**Re:** Proposed public realm improvement works known as the 'Westgate 2040 Project'  
in Drogheda, County Louth

Our Ref: **S177AE Westgate Vision Area**

**Re: Section 177AE application by Louth County Council for Public Realm  
Regeneration Works at Westgate Vision Area, Drogheda, County Louth**

DRAWING  
Sections R-R, H-H and I-I  
Medieval Wall Area

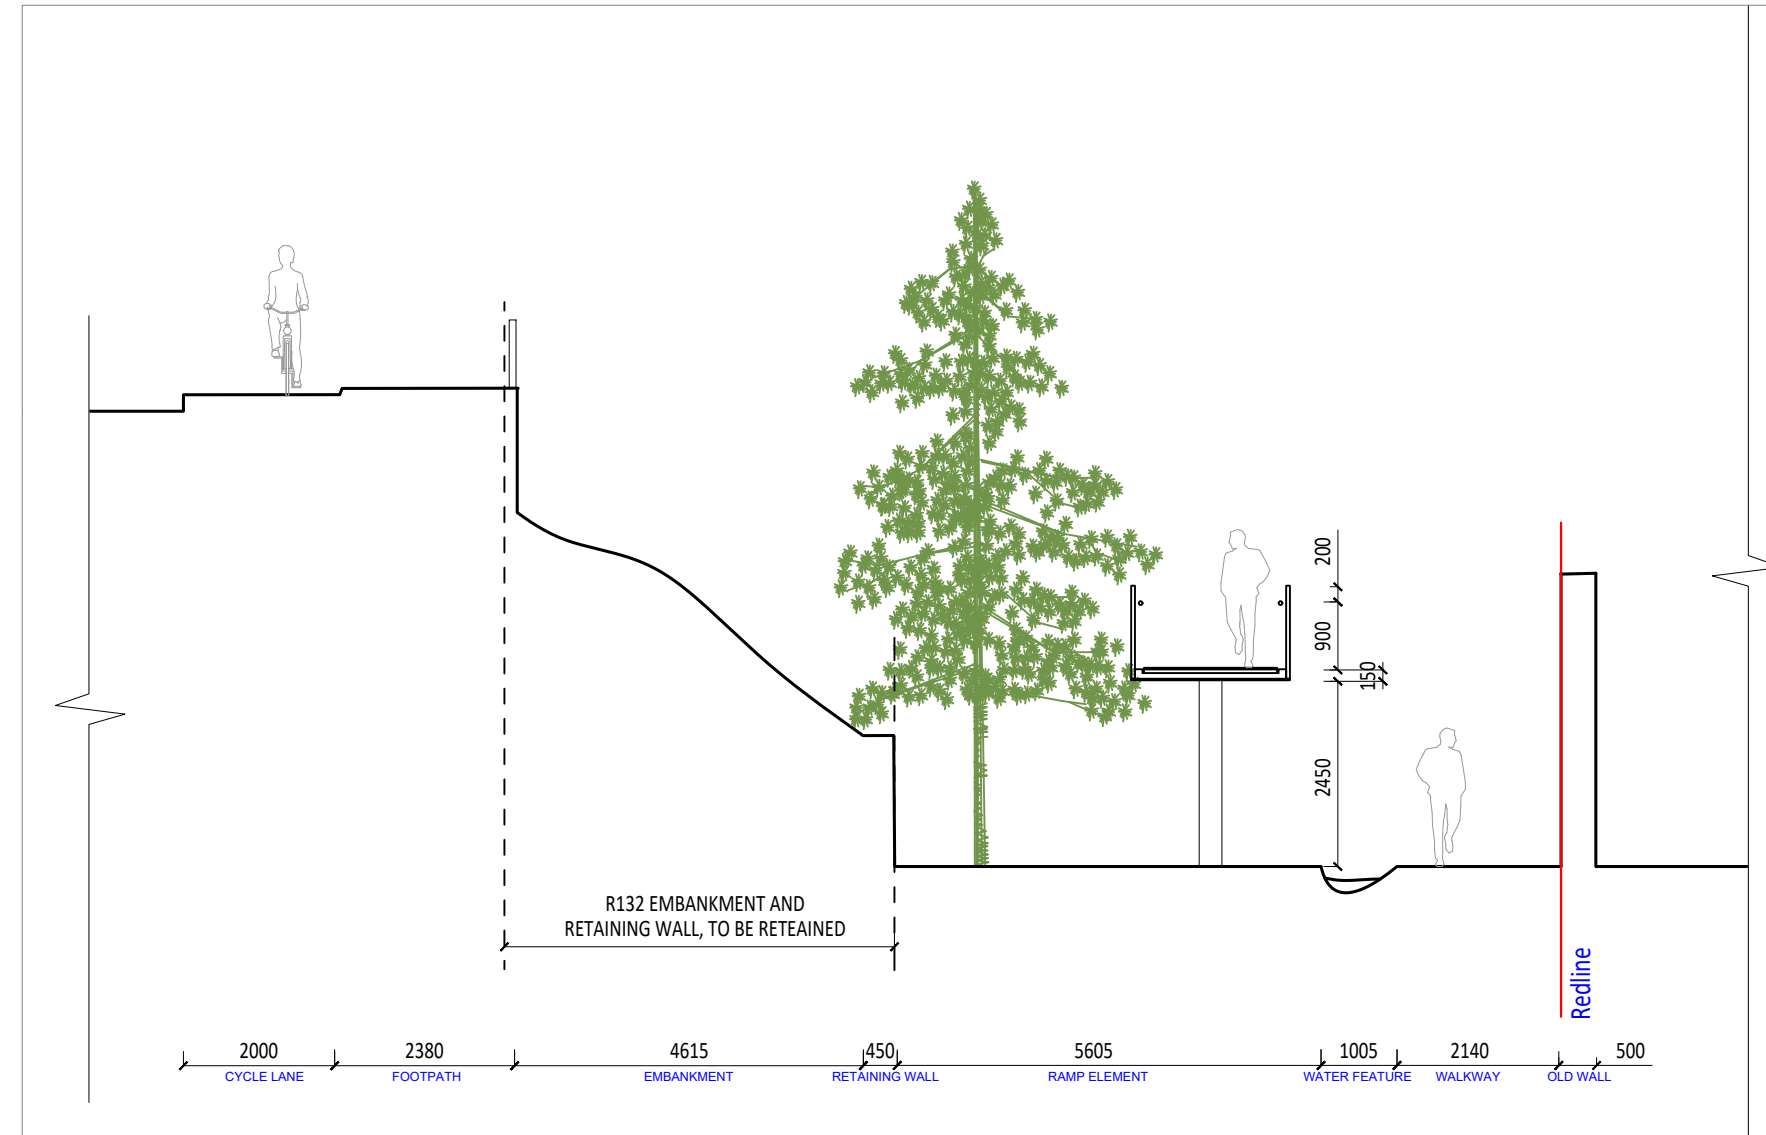
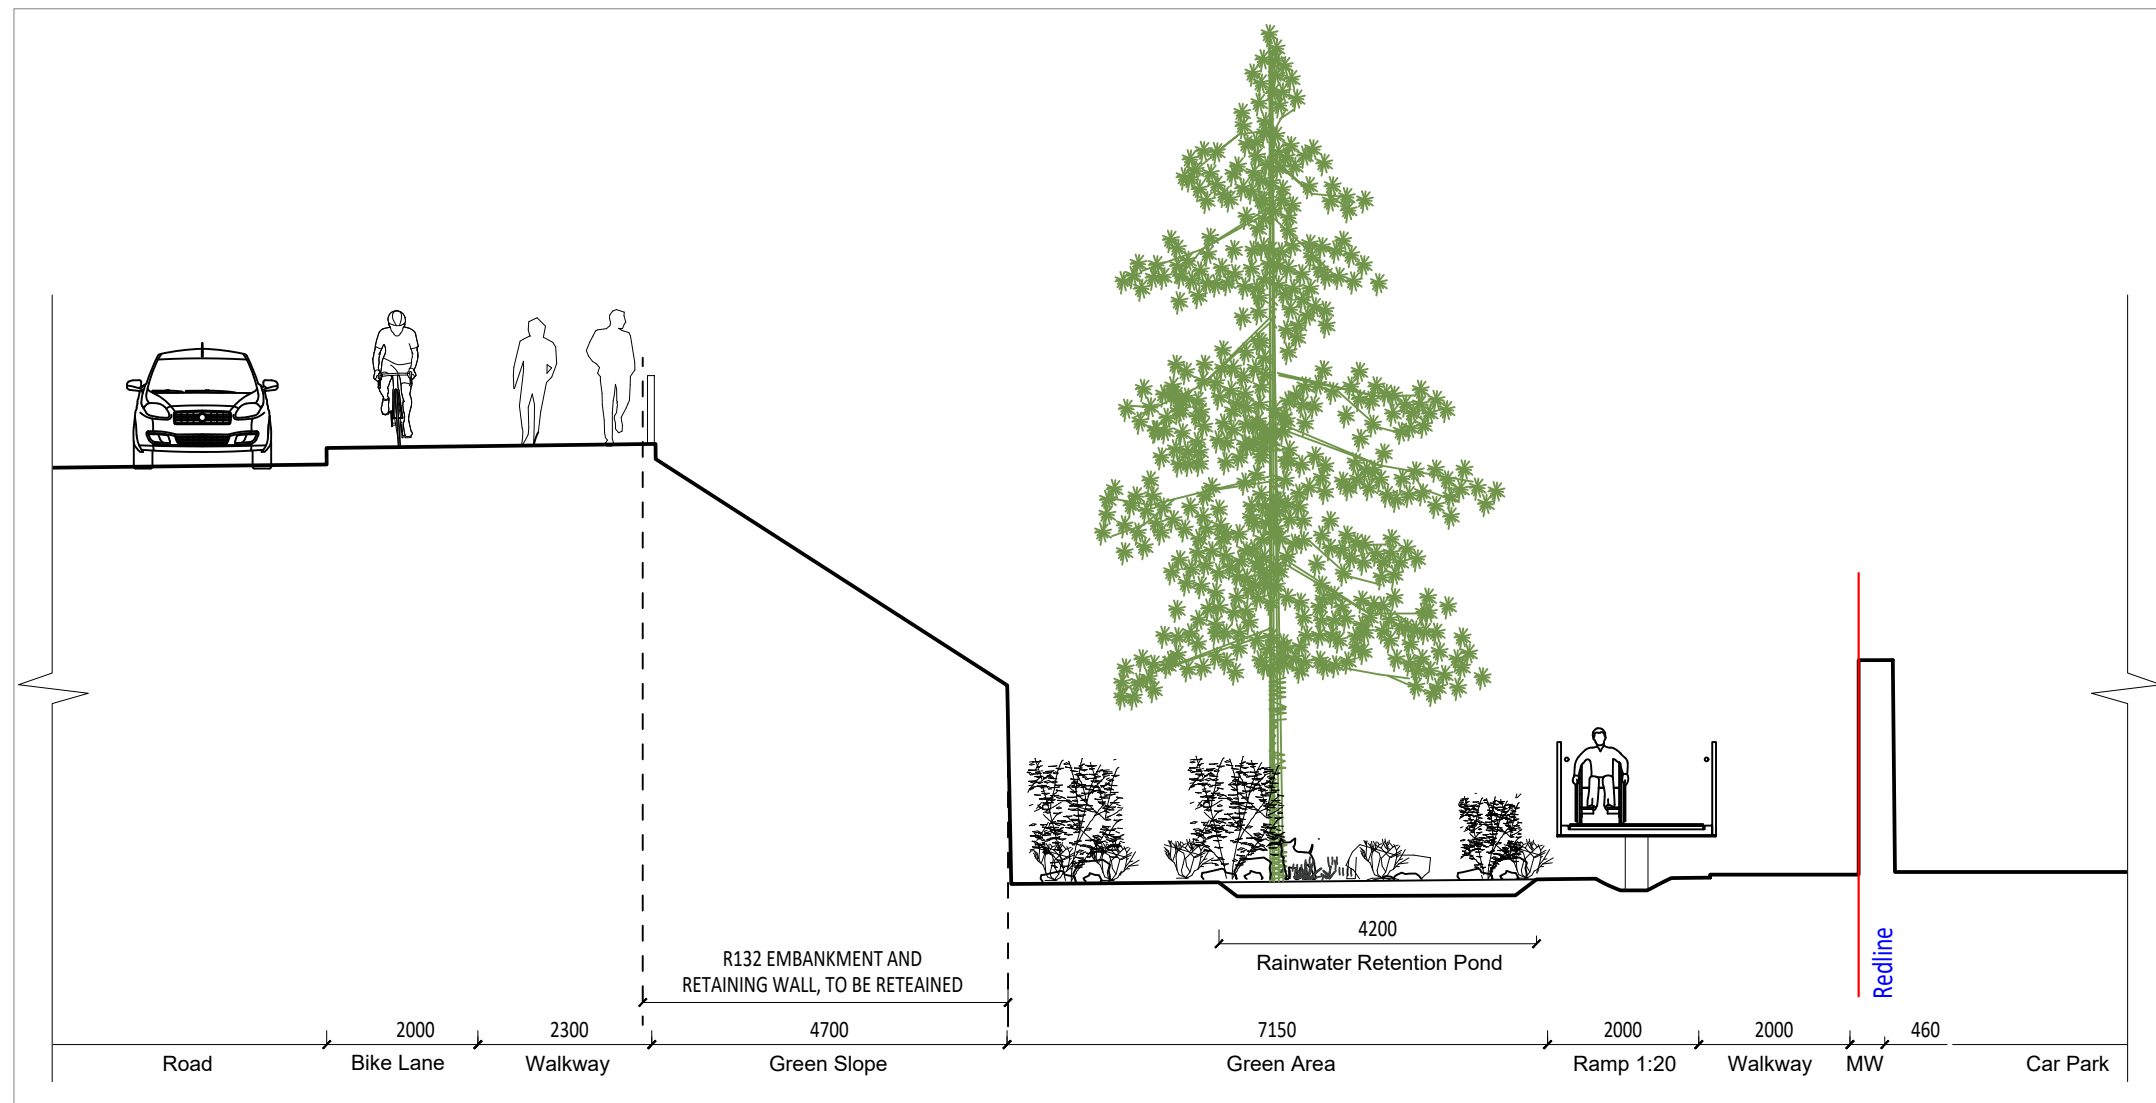
The proposed ramp appears to be of substantial scale and length in the context of the historic setting of the town wall. Whilst greater engagement with the wall is welcome, the proposal

appears not to have fully evaluated the surviving wall, its features and relationship to the river. Proposals for the town wall conservation and interpretation have not been included.

The length and close proximity of the contemporary ramp to sections of the medieval wall creates potentially insecure spaces, the overall dominance of the contemporary design set against the wall appears to diminish the presence or experience of the wall.

The Department recommends the input of a Grade 1 Conservation Architect to review and to amend the proposals by providing advice on cultural significance, the special heritage context of the proposed development, the scale and location of interventions and the presentation of historic fabric and spaces with specifications for repair and conservation.
